Attn. : Jeff Palmer – Code Enforcement Supervisor  
Cc. : Hannah Aulick and Reviewers  
Re. : SI-2024-00597 – SITE PLAN DFT  
 : 2026 Central SW  
Project No. : PR-2023-009688

I apologize for my lack of quality control on the last submittal as some of the items were on the drawings however on non-printing layers. We have prepared individual responses to each of your previous comments that did not receive clear and complete responses and verified that those responses are clearly reflected in the plots being submitted to you.

01 EXTERIOR ELEVATION
EAST FACADE
SCALE: 1/8" = 1'-0"

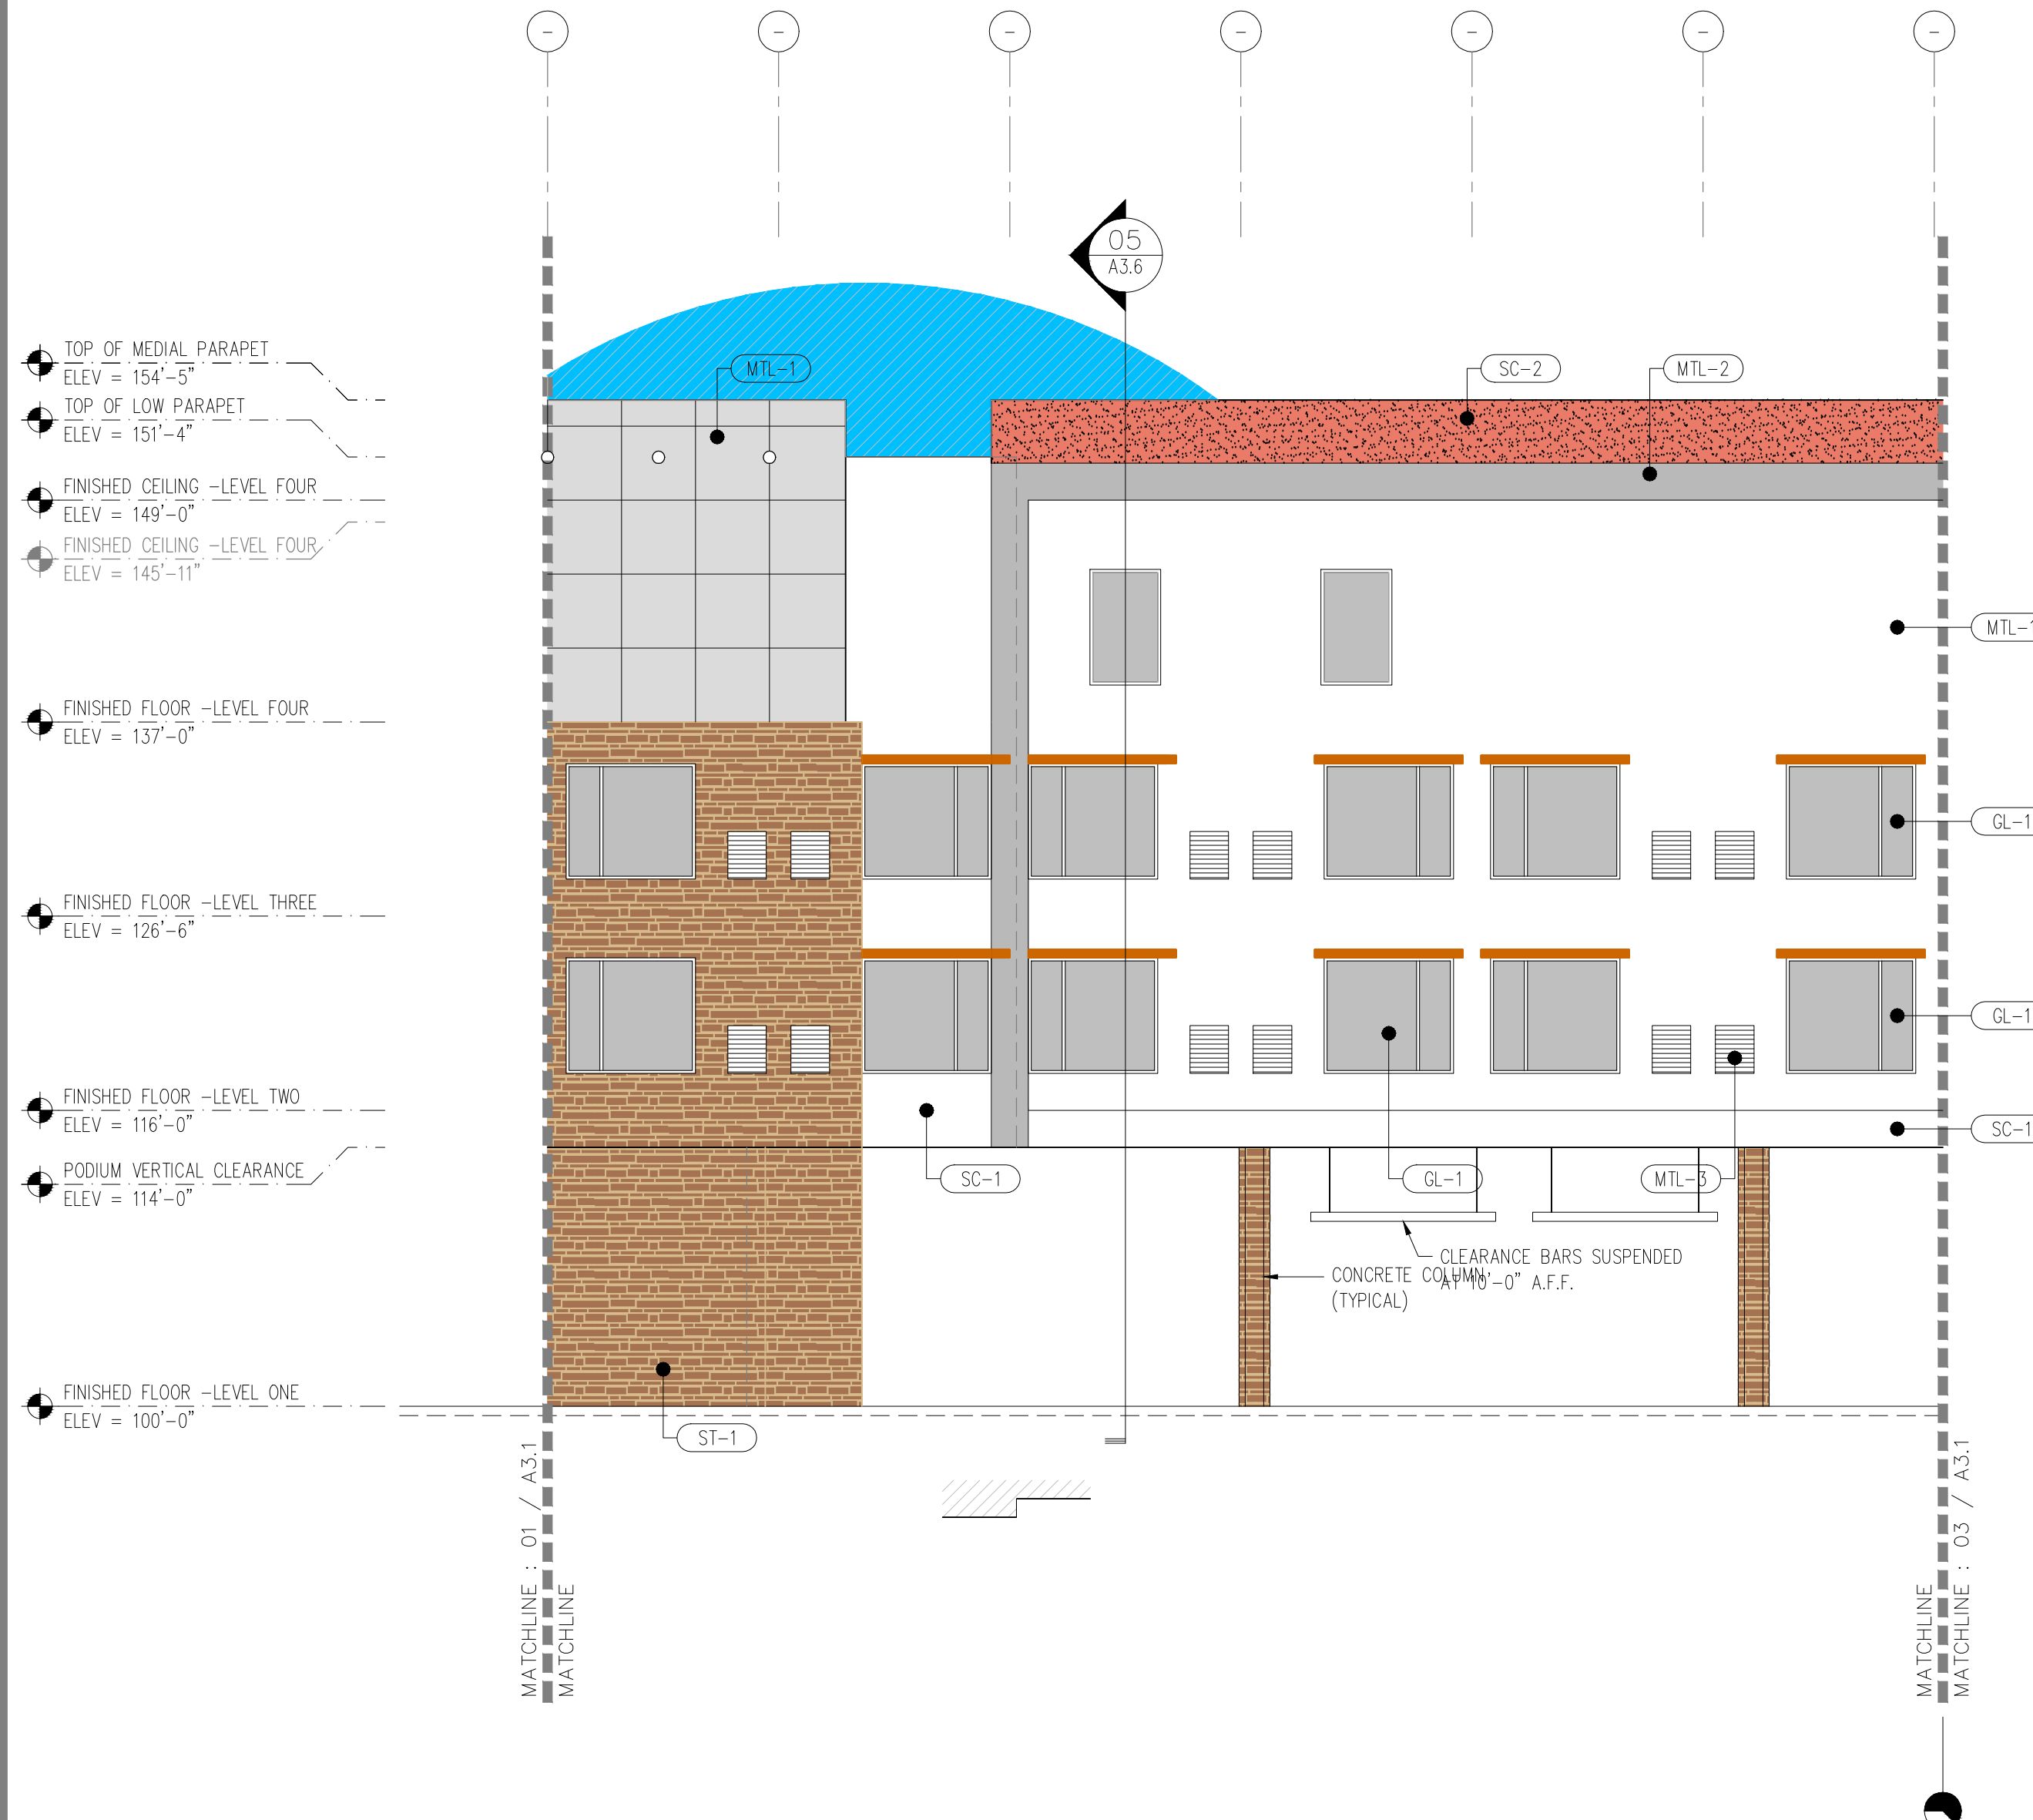
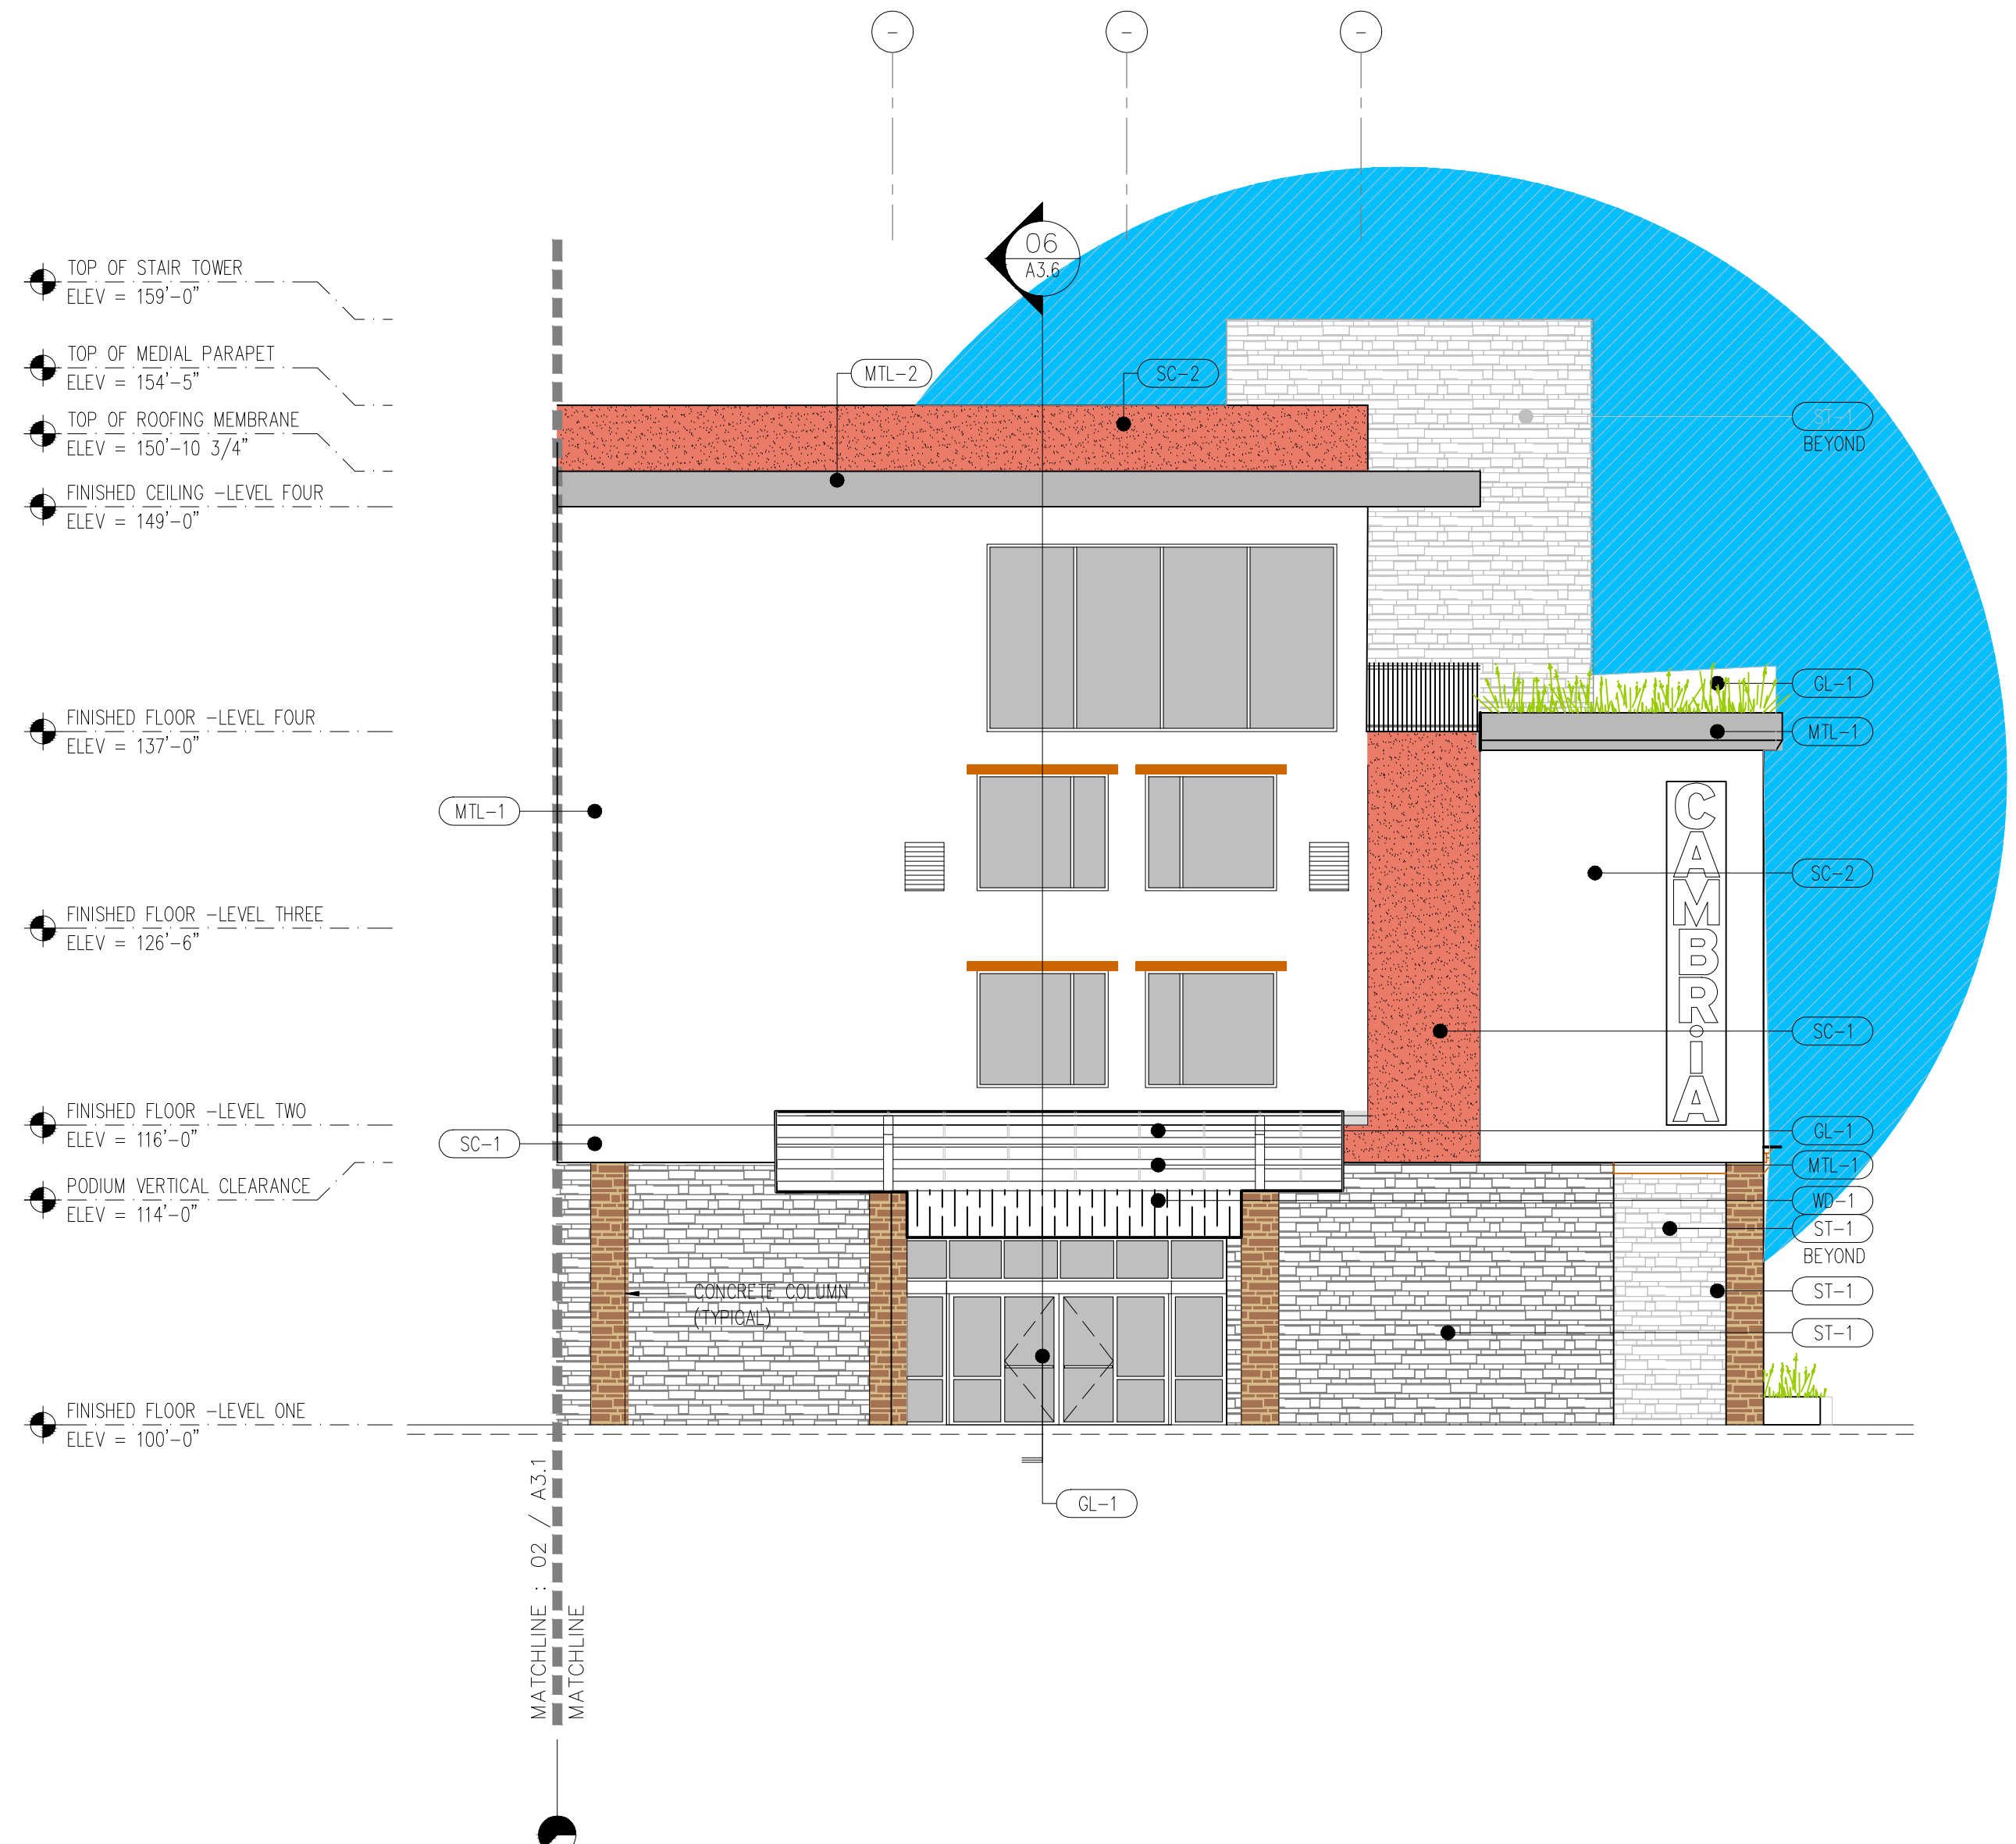
- 12 *Comment* - 5-5(G)(3)(b) No horizontal length of any façade shall extend longer than 40 feet without the inclusion of architectural elements such as decorative grillwork, louvers, translucent screens, alternating building materials, projection of lintels, portals, and other external features to avoid visual monotony. A change in color alone does not satisfy this requirement. Confirm compliance.

*Response: Concur. The elevations have some lintels shown, but we have added some other architectural elements in the stretches of elevation that are more than 40' to avoid visual monotony.*
